Reference: 20240241-L07_ssda response letter.docx

Date: December 3, 2025

RE: 15A & 15B MOSELEY STREET, CARLINGFORD – RESPONSES TO ENGINEERING COMMENTS RAISED BY THE DEPARTMENT

Drawing Title
**GENERAL ARRANGEMENT PLAN
SHEET 01 OF 02**

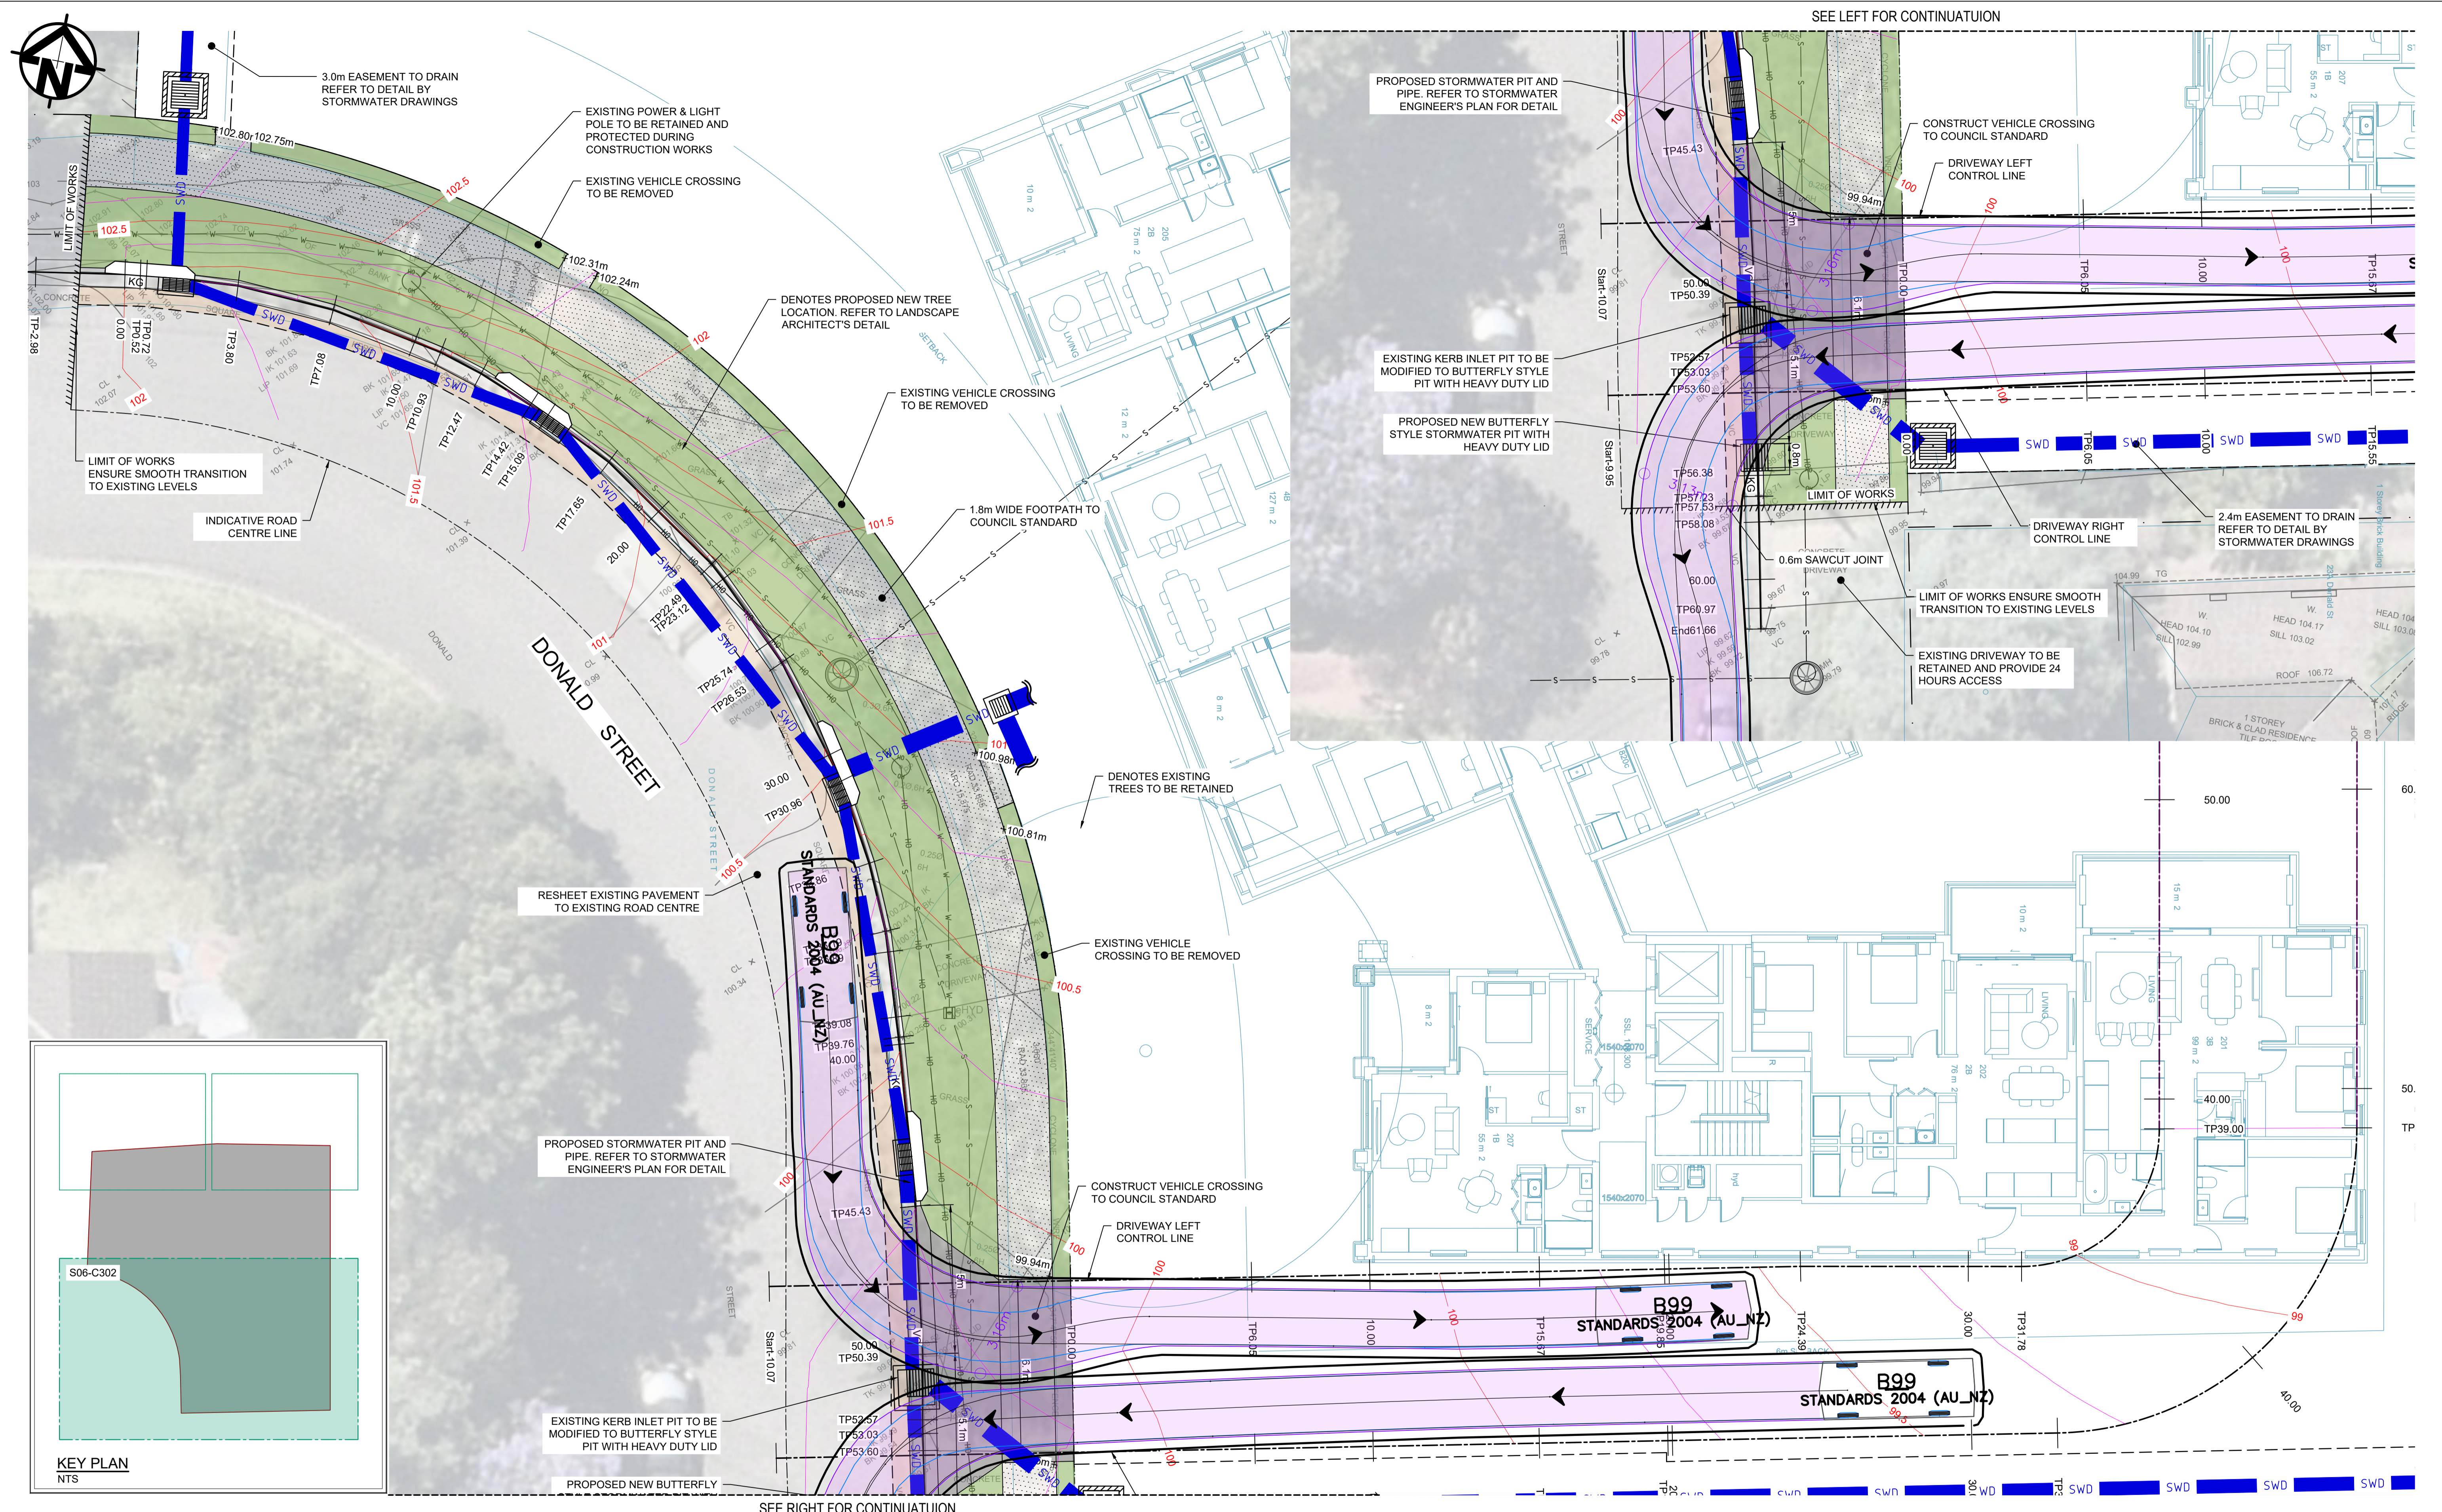
6. The proposed driveway ramp from Moseley Street is not shown on the stormwater drainage plans and appears to be completely negative fall from Moseley Street. A section of positive fall shall be included in this driveway to ensure that kerb flows in Moseley Street do not enter the property. The proposed location of this driveway also conflicts with the proposed kerb inlet Pit 1.03 in Moseley Street

SGC: This can be captured in the construction certificate stage and the public domain levels will dictate the footpath levels. The pit is not within the driveway layout. This was coordinated by the design team.

ROAD LONGITUDINAL SECTION ALONG DRIVEWAY LEFT CONTROL LINE
SCALE H:1in100 V:1in100

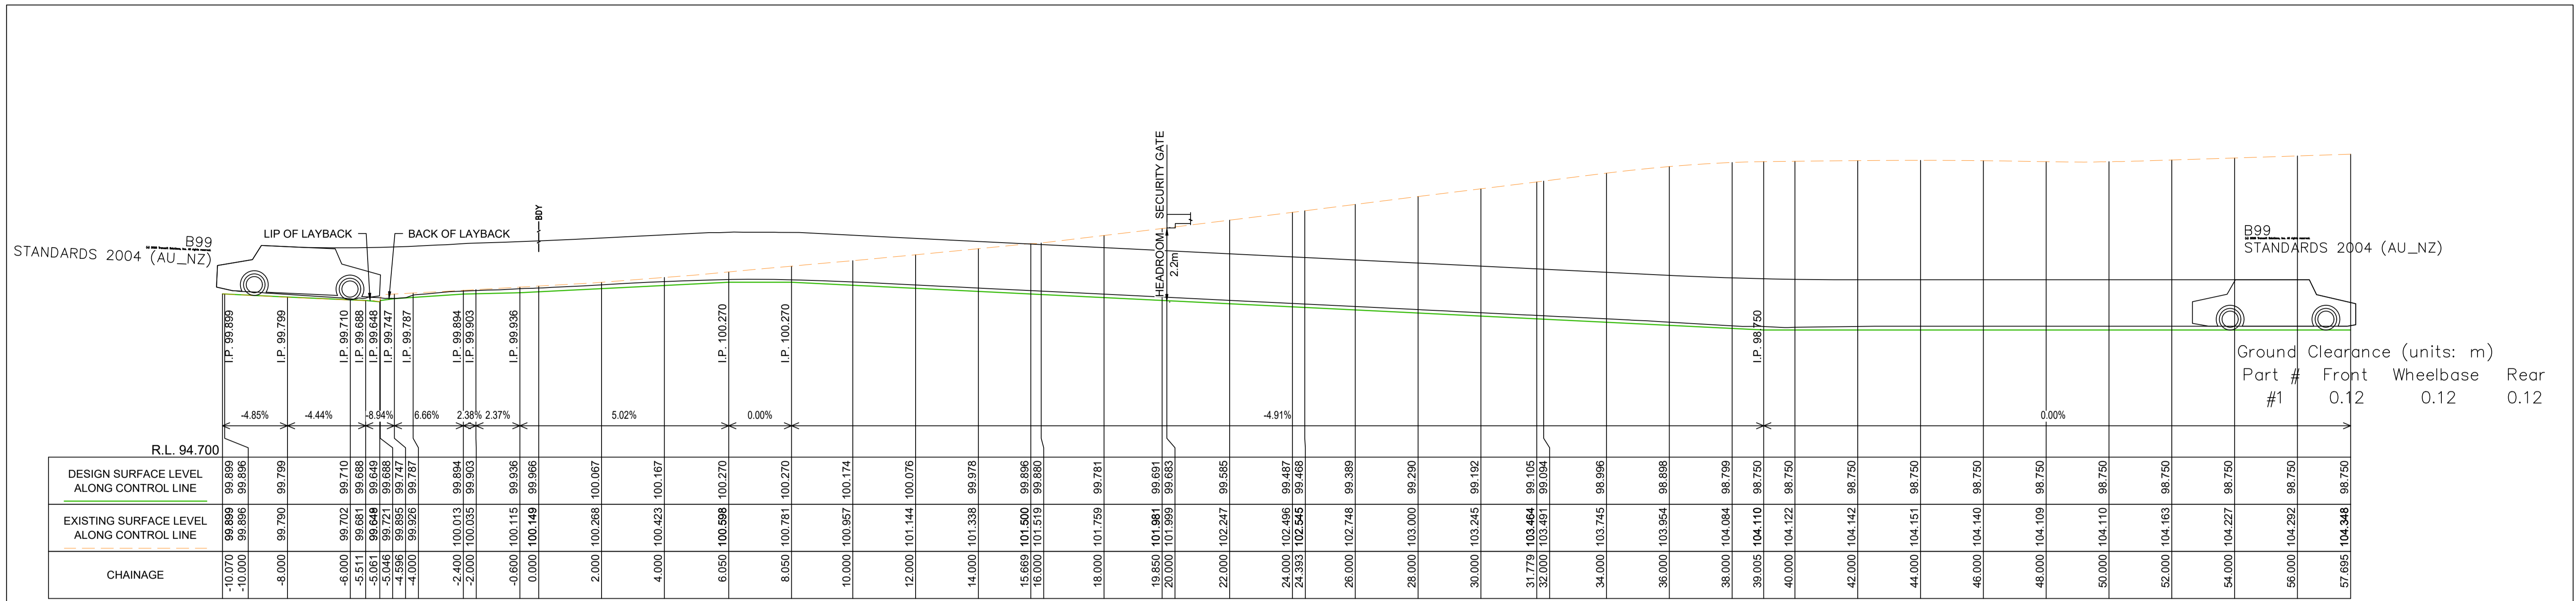
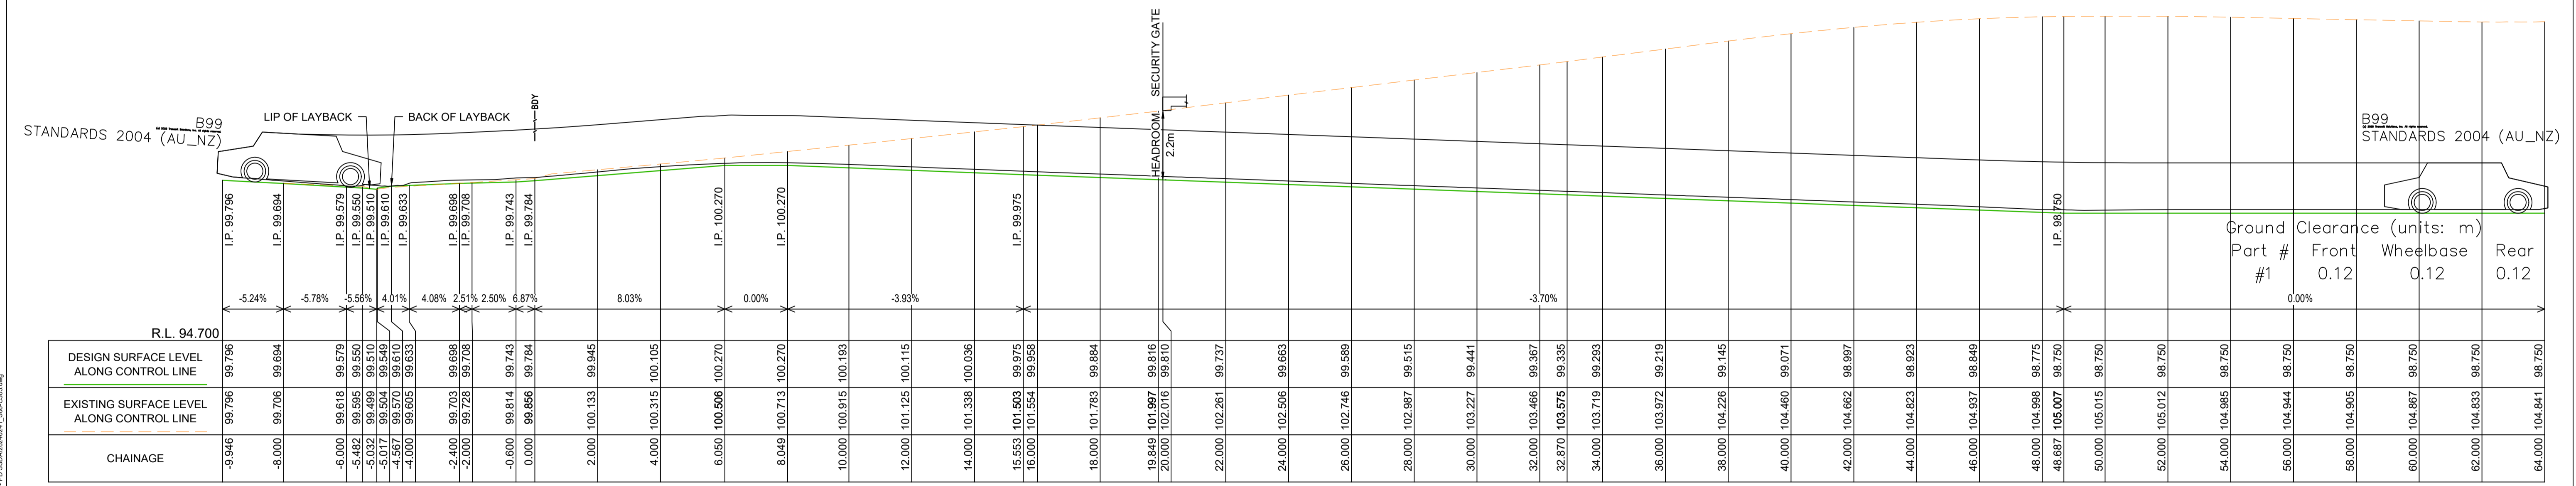
5. The minimum bund level for the basement driveway ramp from Donald Street should be RL100.27m AHD as per the Northrop assessment (SY231114-00-CVLE01-1, dated 7/11/24),
SGC: refer to amended civil concept plans which increase the crest level from 100.20 to 100.27.
